DRB Application No.: 09DRB-70101 Project # 1007008  
Project Name: Graceland Acres Addn.  
Agent: Darren Sowell Architects Phone No.:

**DRB Comments**

**PROJECT # 1007008**

**Date:** Feb. 2, 2009  
**To:** Jack Cloud, DRB Chair  
**From:** Carol Toffaleti, Staff Planner, Development Review, 924-3345  
**cc:** Craig Calvert, DSA Architects  
**Subject:** Project #1007008 – JLM Auto Sales at Candelaria/Arno  
07EPC-40104 Zone Map Amendment, 08EPC-40086 Site Development  
Plan for Building Permit

**SOLAR COLLECTOR INSTALLATIONS**

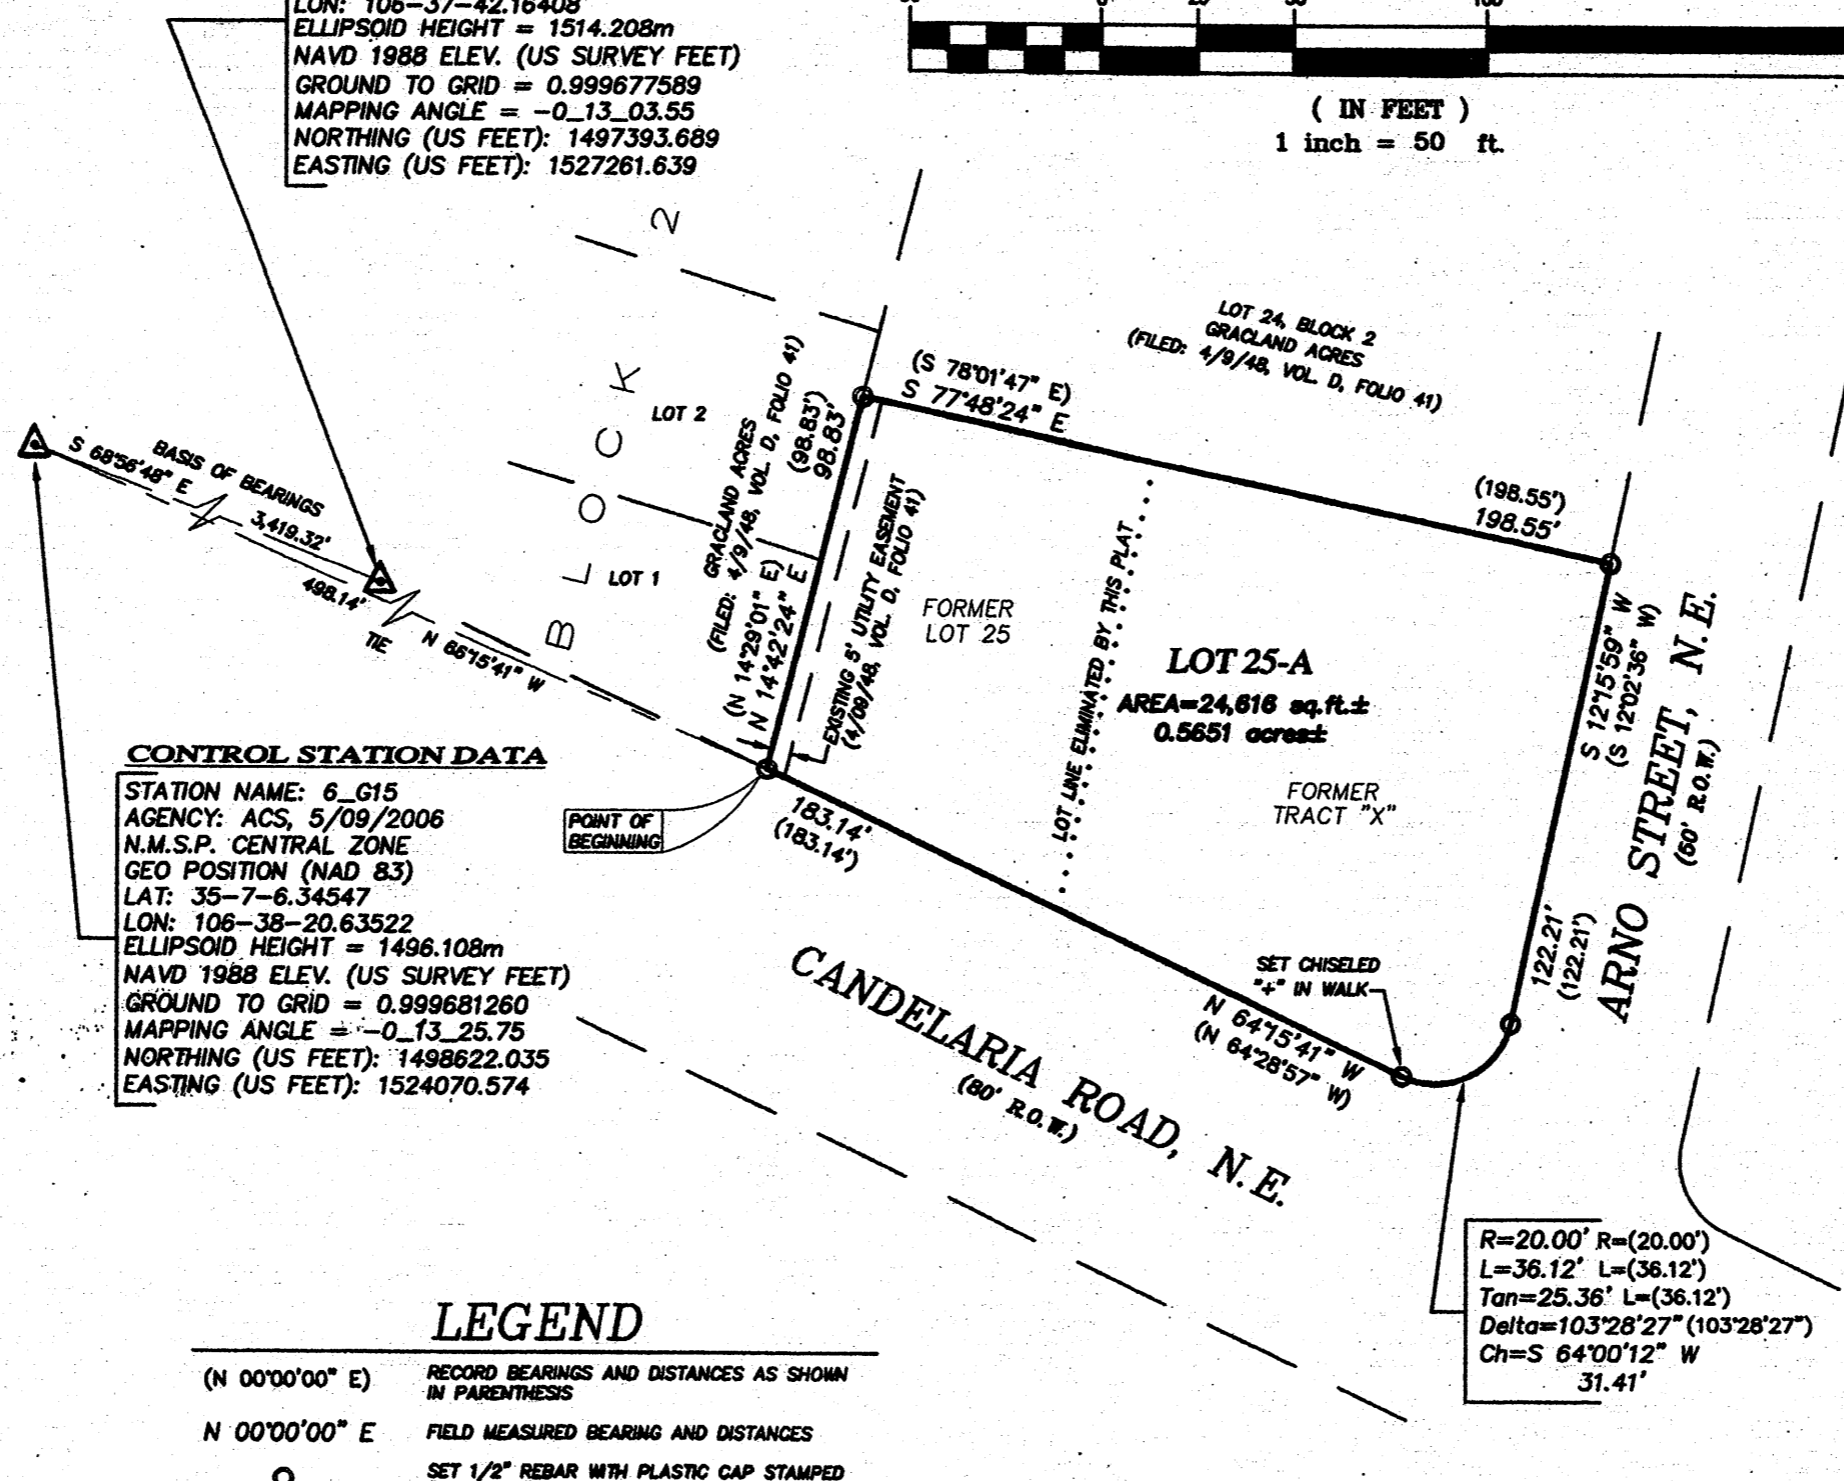
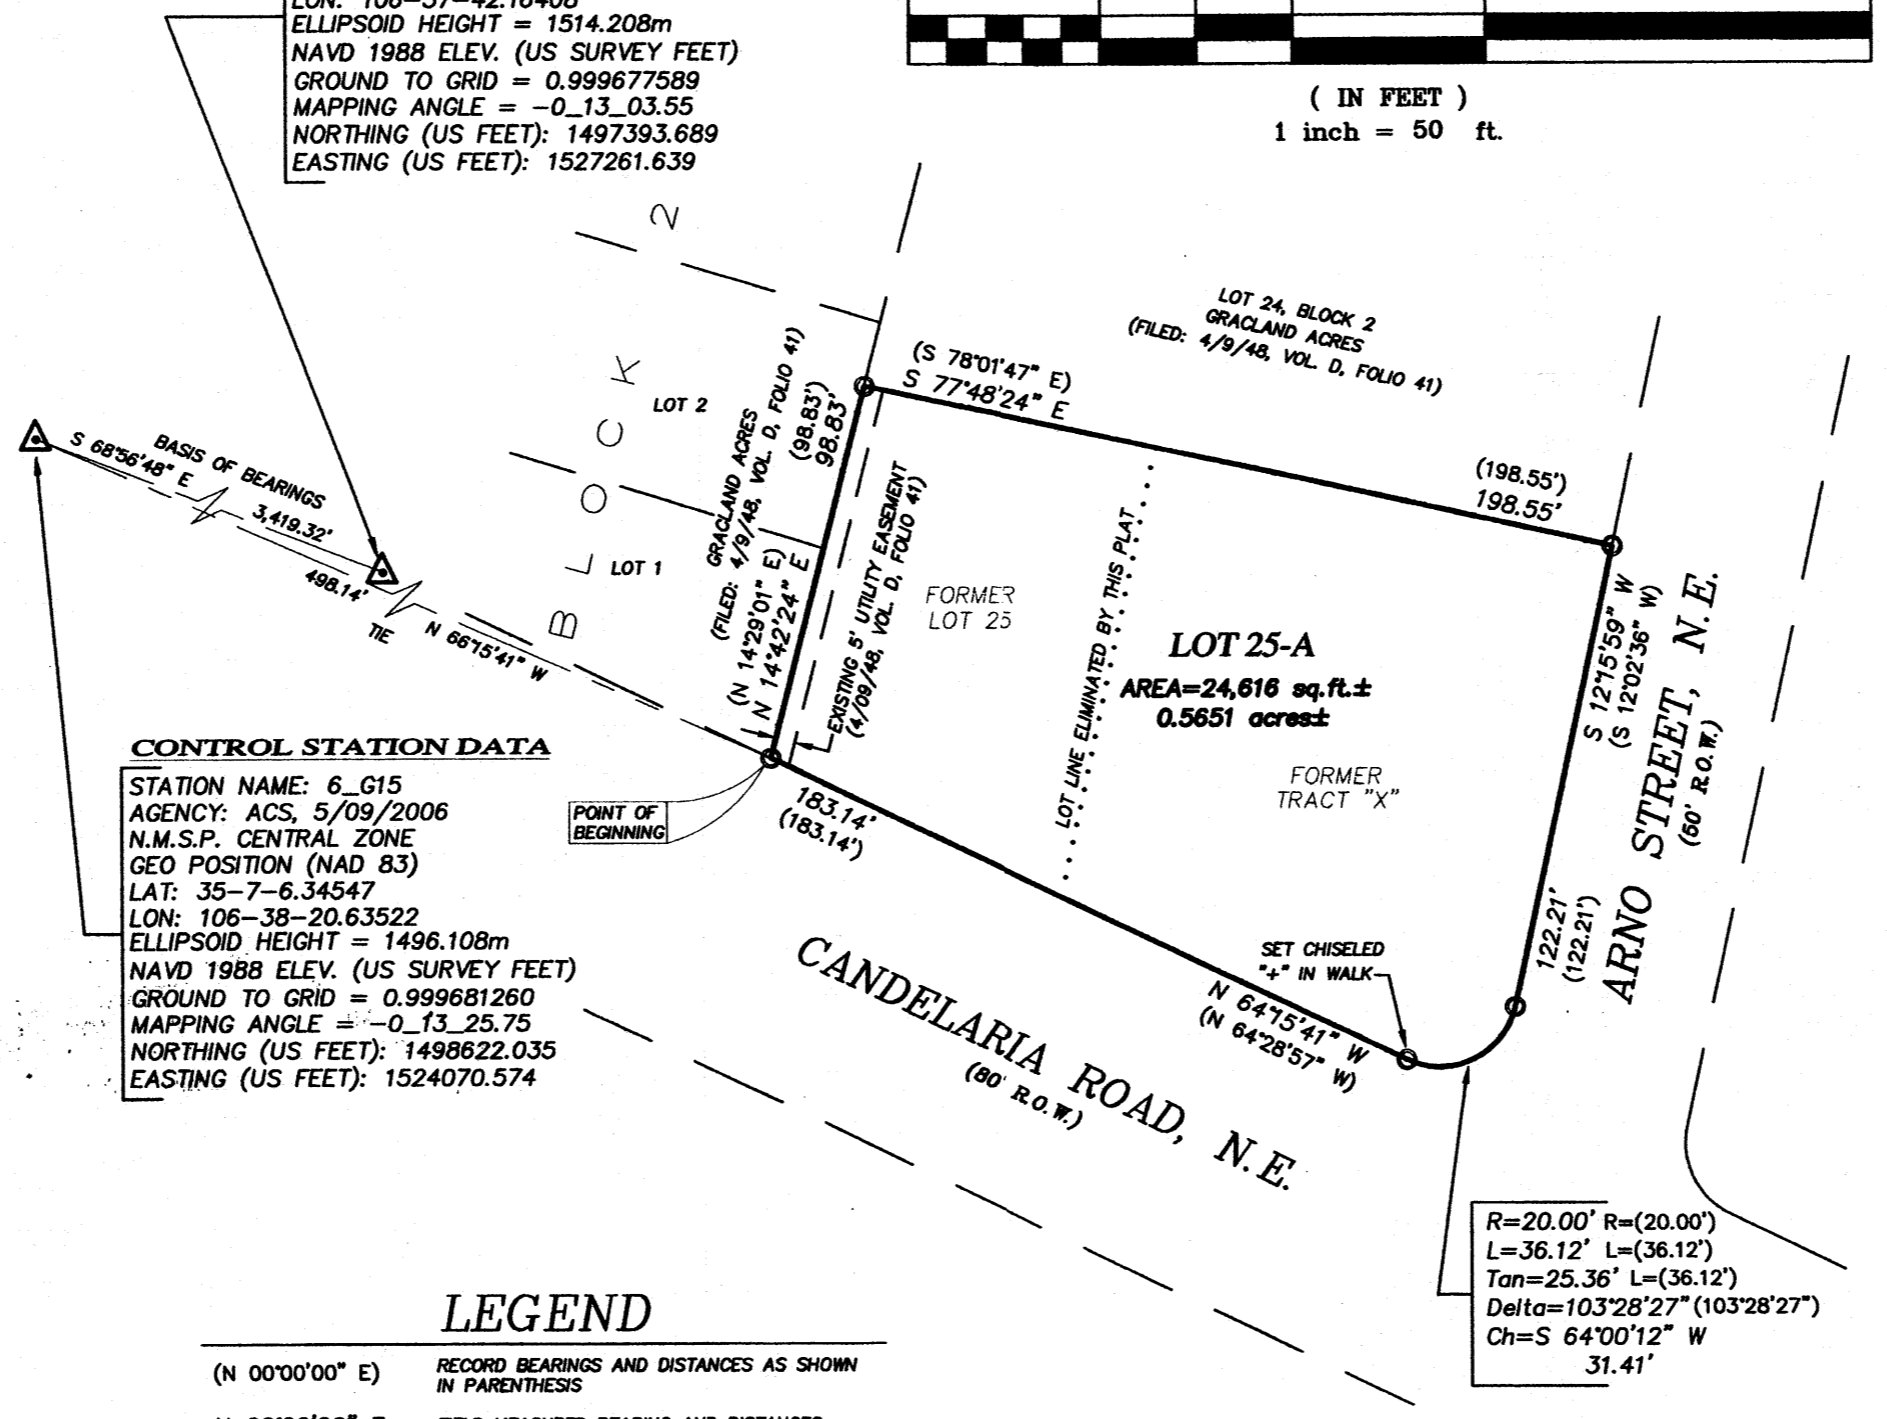
A Solar Note will be needed on the plat (consistent with Section 14-14-4-7 of the Subdivision Ordinance) which is specific to this type of request, i.e. use the words "THIS PLAT" (rather than the words "REQUESTED FINAL ACTION") at the beginning of the note, and do not use the words "OR SITE DEVELOPMENT PLAN FOR SUBDIVISION" at the end of the note.
